2022/1292

Erection of a single storey side extension to the bungalow

16 Bowfell View, Smithies, Barnsley, S71 2AE

PROPOSED PLAN & ELEVATIONS

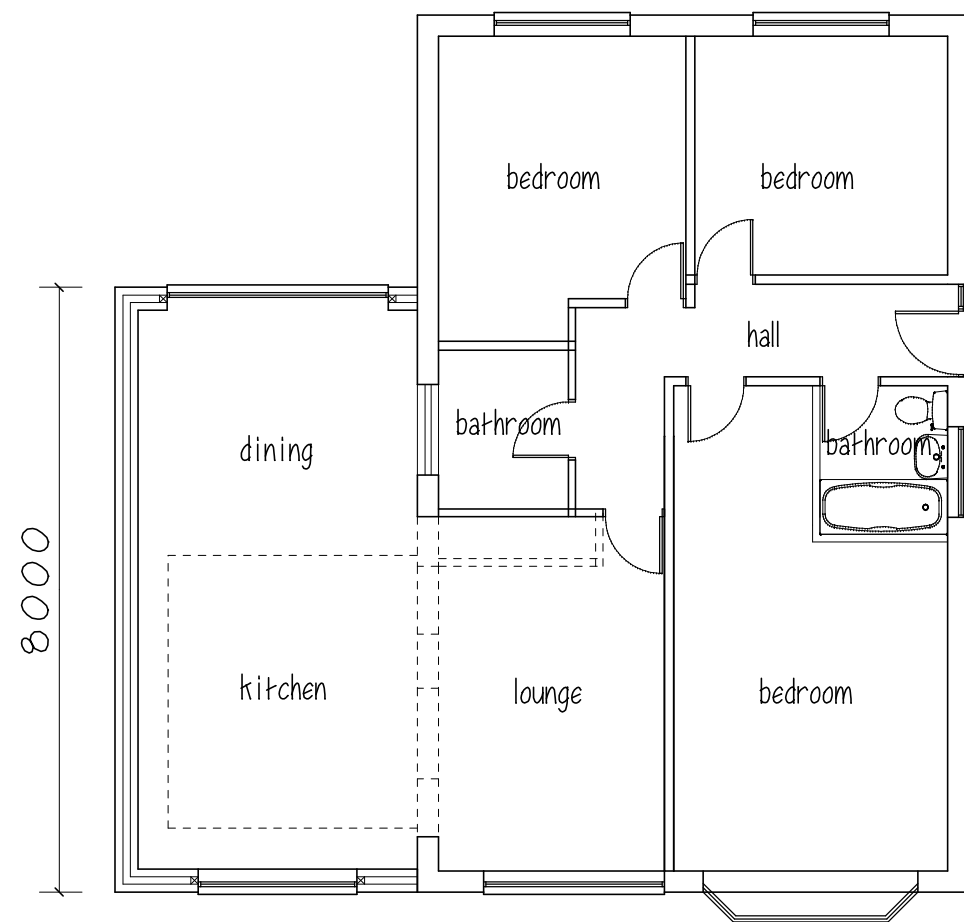
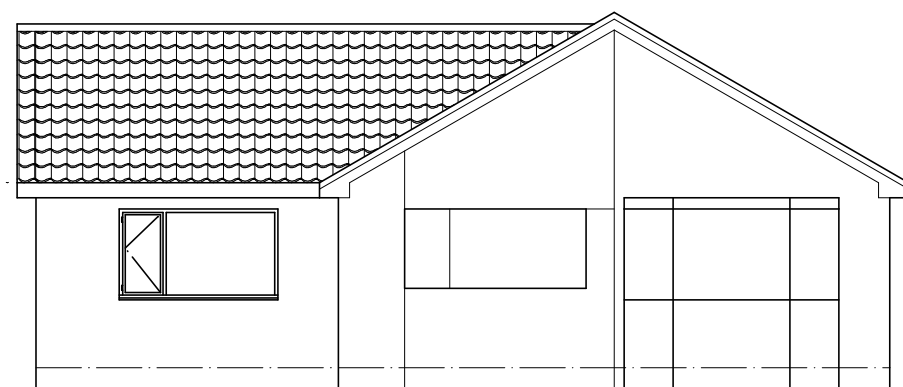
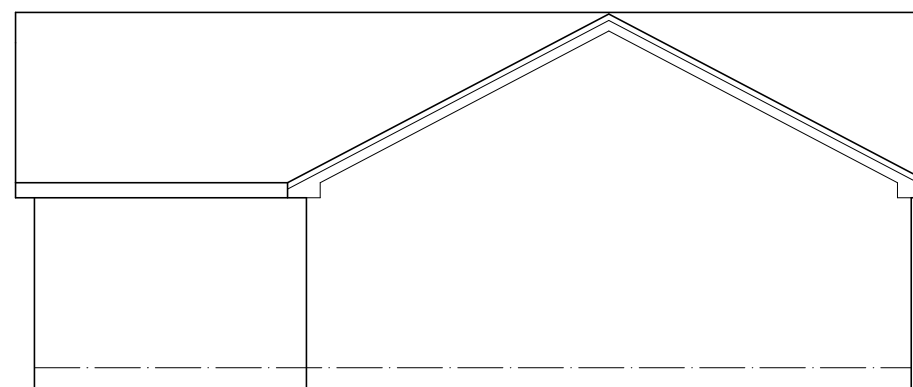
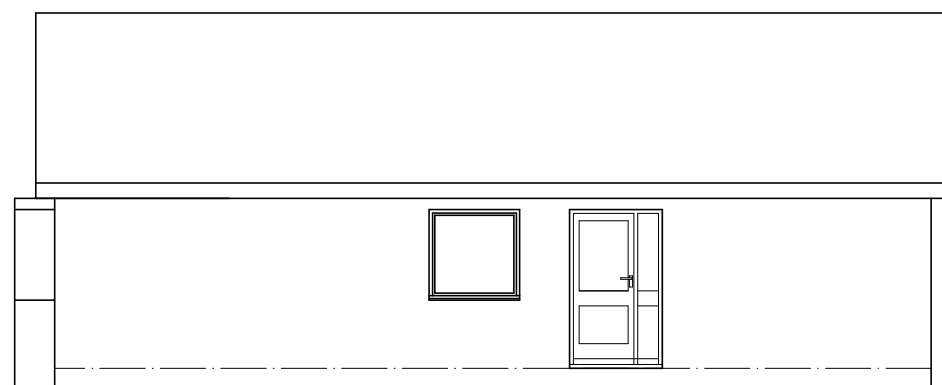
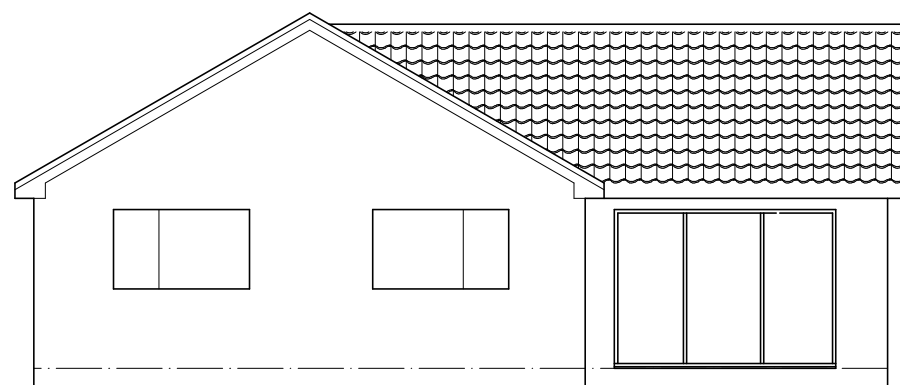
The Supplementary Planning Document - House Extensions and other Domestic Alterations states that 'the design of single-storey side extensions should reflect the design of the existing dwelling in terms of roof style, pitch materials and detailing and should not have an excessive sideways projection, i.e., more than two-thirds the width of the original dwelling.' In this instance the proposed extension projects 4m from the side elevation and therefore complies with the guidance set out in the SPD.

The document also states that a two-storey side extension should have a set back from the front elevation by at least 500mm, to allow for a vertical break in the roof plane, a lowering of the ridge line and to reduce the terracing effect. Whilst a single storey dwelling, the proposal is tantamount to a two-storey extension on a two-storey property. The set-back also lessens the unsightly bonding of old and new materials; the proposal does not allow for a set-back and although there is no corresponding lowering of the ridge line, the design of the extension roof, ensures that the extension remains subservient with the main dwelling remaining the dominant feature. The design put forward is a replica of figure 6.7 on page 7 of the Supplementary Planning Document.

The extension would be located on the southern elevation and could form a dominant feature within the Burton Bank Road street scene, however, the extension would be screened by the existing conifer hedge which is to be retained. In addition, the extension is designed to harmonise with the original dwelling in terms of roof style and pitch, and fenestration, and is to be constructed from materials which match the original dwelling. Therefore, it is considered that the proposed extension is acceptable in terms of visual amenity and in compliance with Local Plan Policy D1: High Quality Design and Place Making.

The proposed extension is to be located on the southern side elevation, within the building line of the original dwelling and therefore would not increase levels of overshadowing or loss of outlook from the neighbouring dwellings. There are no windows proposed on the side elevation, and those on the front and rear elevations are located a sufficient distance from the respective boundaries not to increase levels of overlooking.
